KITTITAS COUNTY DEPARTMENT OF PUBLIC WORKS

MEMORANDUM

TO: Jeff Watson, Community Development Services
FROM: Christina Wollman, Planner II *W*
DATE: August 5, 2010
SUBJECT: Haberman BL-10-00023

Proposed Boundary

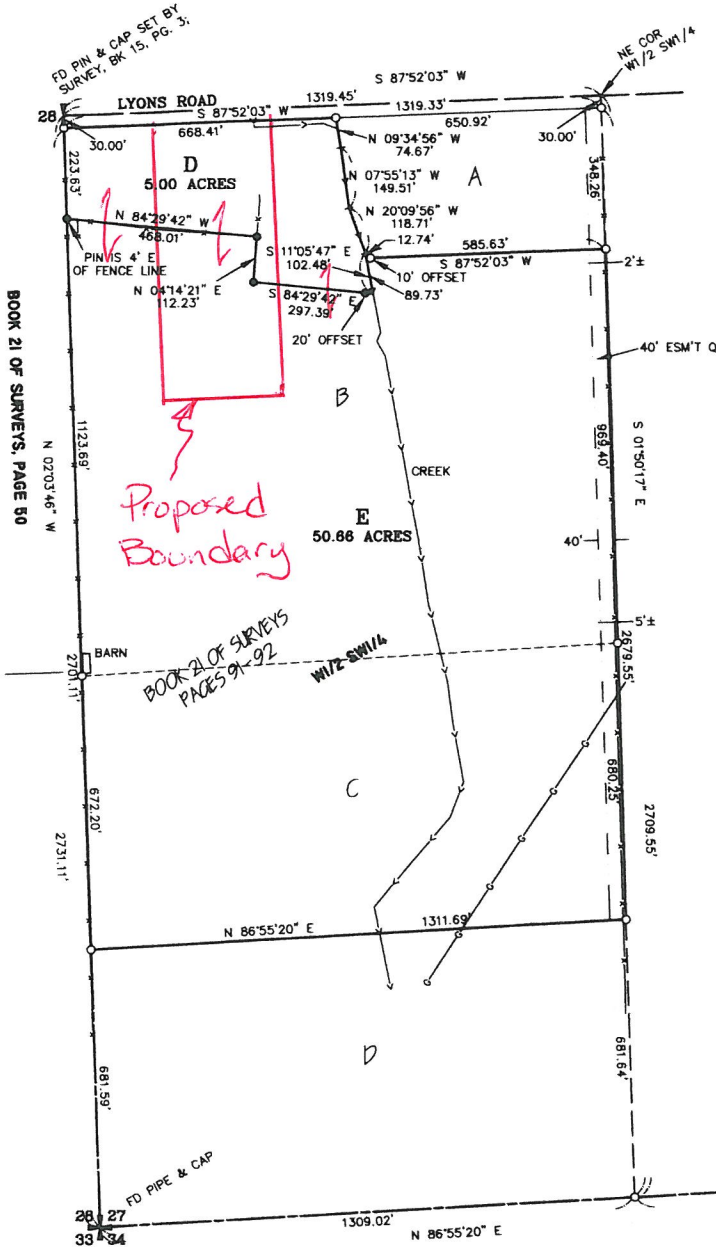
1. The proposed access with appropriate easement(s) shall be shown and shall conform to applicable Kittitas County Road Standards.
2. A revised legal description that describes the final configuration of the subject property shall be required.
